D49 TRANSPORTATION CENTER
SCHOOL DISTRICT NO 49
11971 SWINGLINE ROAD
PEYTON, CO 80831

SHEET TITLE
**INITIAL
EROSION
CONTROL PLAN
A**

CE1.1

CE1.1

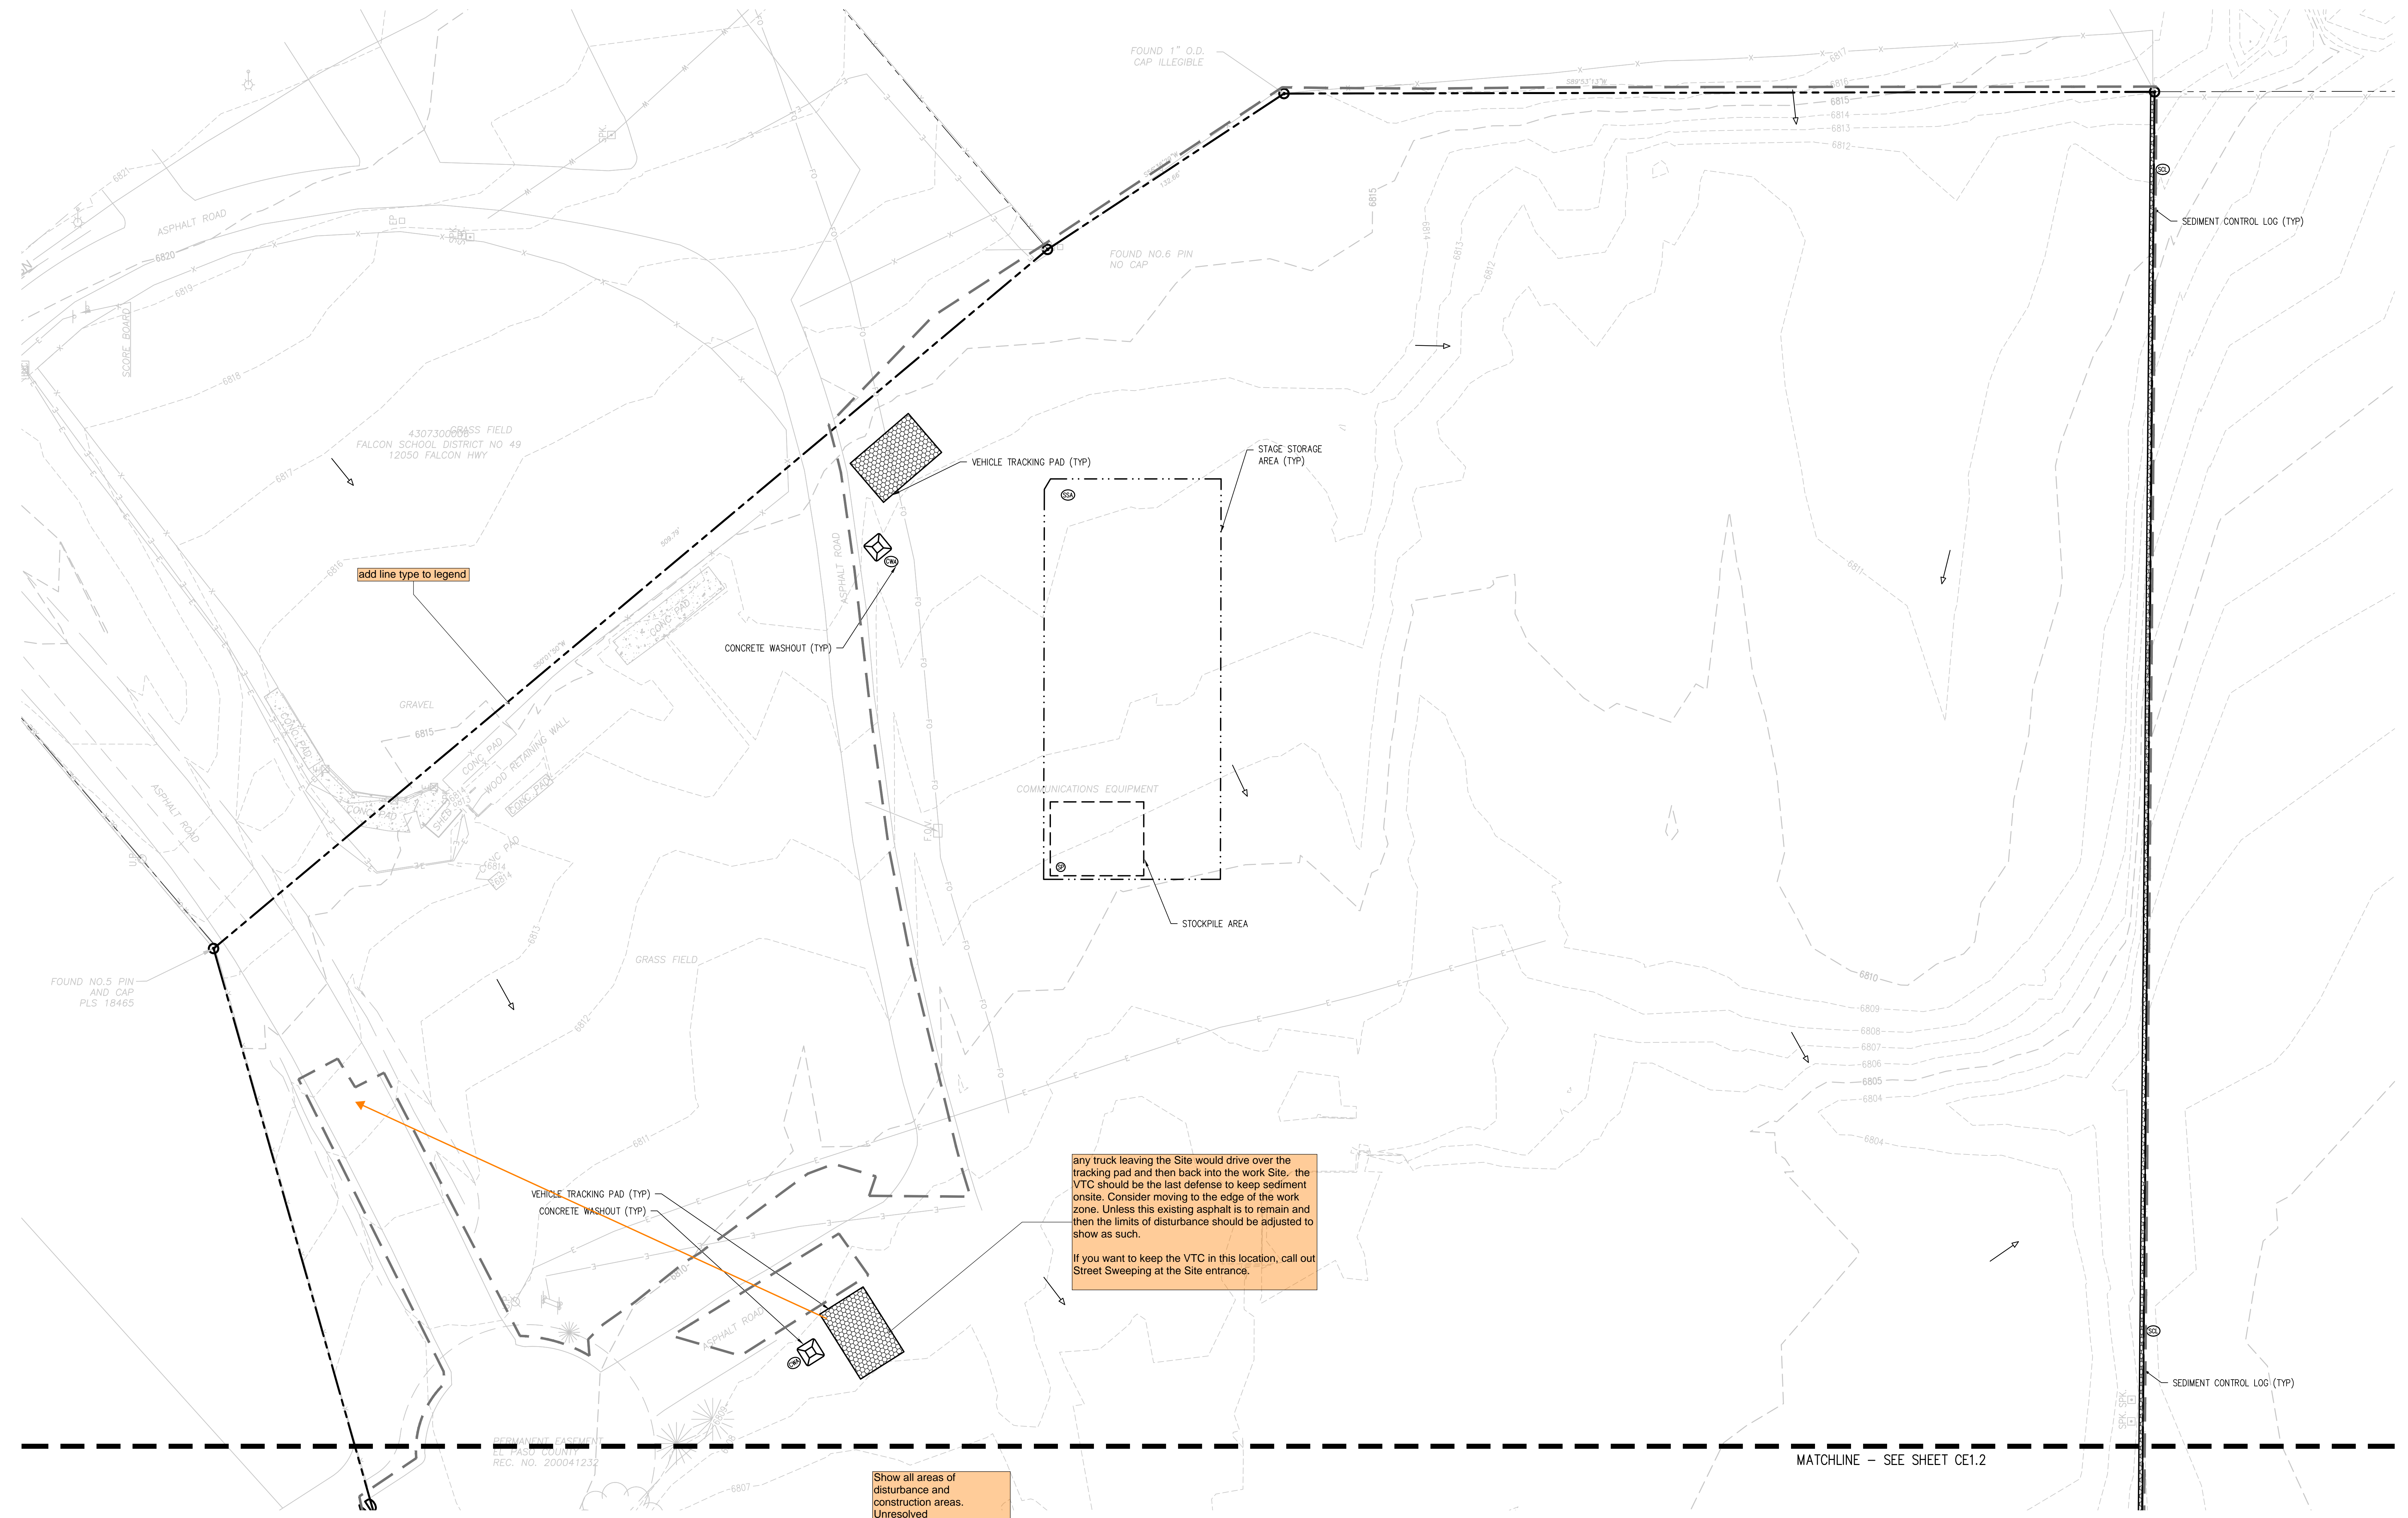
add line type to legend
JVA Response: Line is a property line, see legend notes and abbreviations sheet Co.2 (typ).

any truck leaving the Site would drive over the tracking pad and then back into the work Site, the VTC should be the last defense to keep sediment onsite. Consider moving to the edge of the work zone. Unless this existing asphalt is to remain and then the limits of disturbance should be adjusted to show as such.
If you want to keep the VTC in this location, call out Street Sweeping at the Site entrance.
JVA Response: The VTC is updated to the proposed location.

Show all areas of disturbance and construction areas. Unresolved
JVA Response: See updated GEC set.

CE1.2

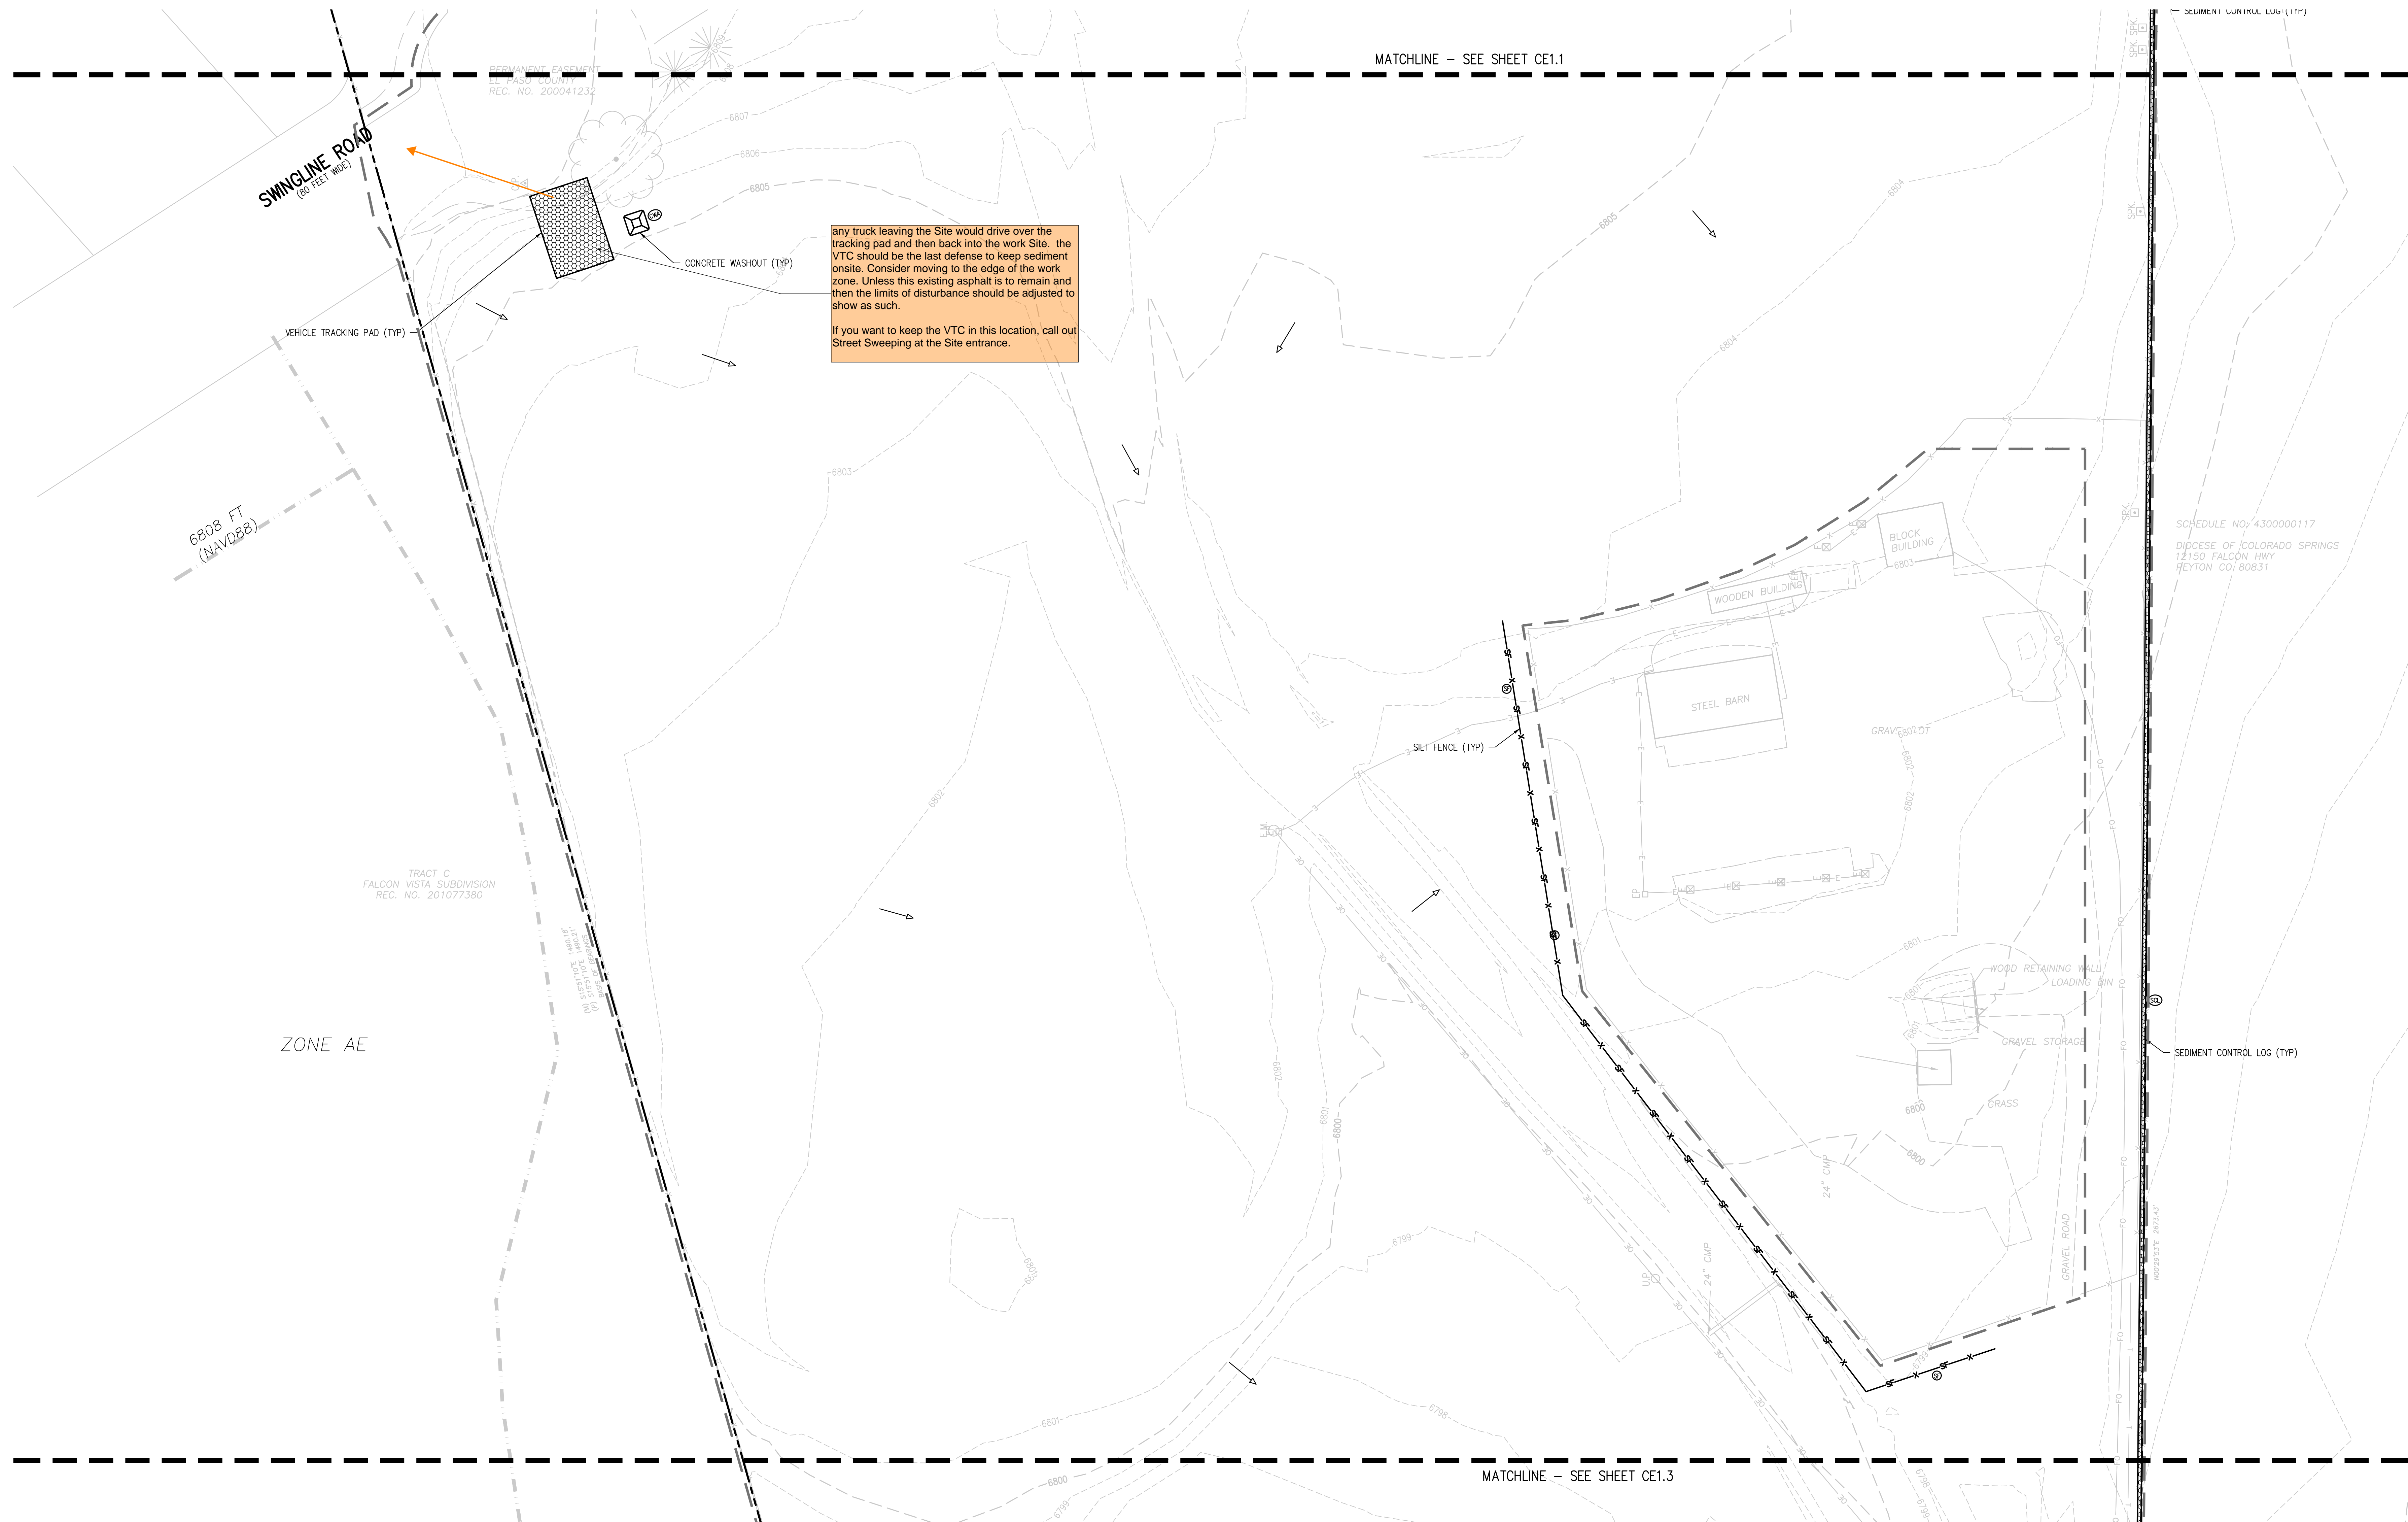
any truck leaving the Site would drive over the tracking pad and then back into the work Site. the VTC should be the last defense to keep sediment onsite. Consider moving to the edge of the work zone. Unless this existing asphalt is to remain and then the limits of disturbance should be adjusted to show as such.

If you want to keep the VTC in this location, call out Street Sweeping at the Site entrance.

JVA Response: The VTC is updated to the proposed location.
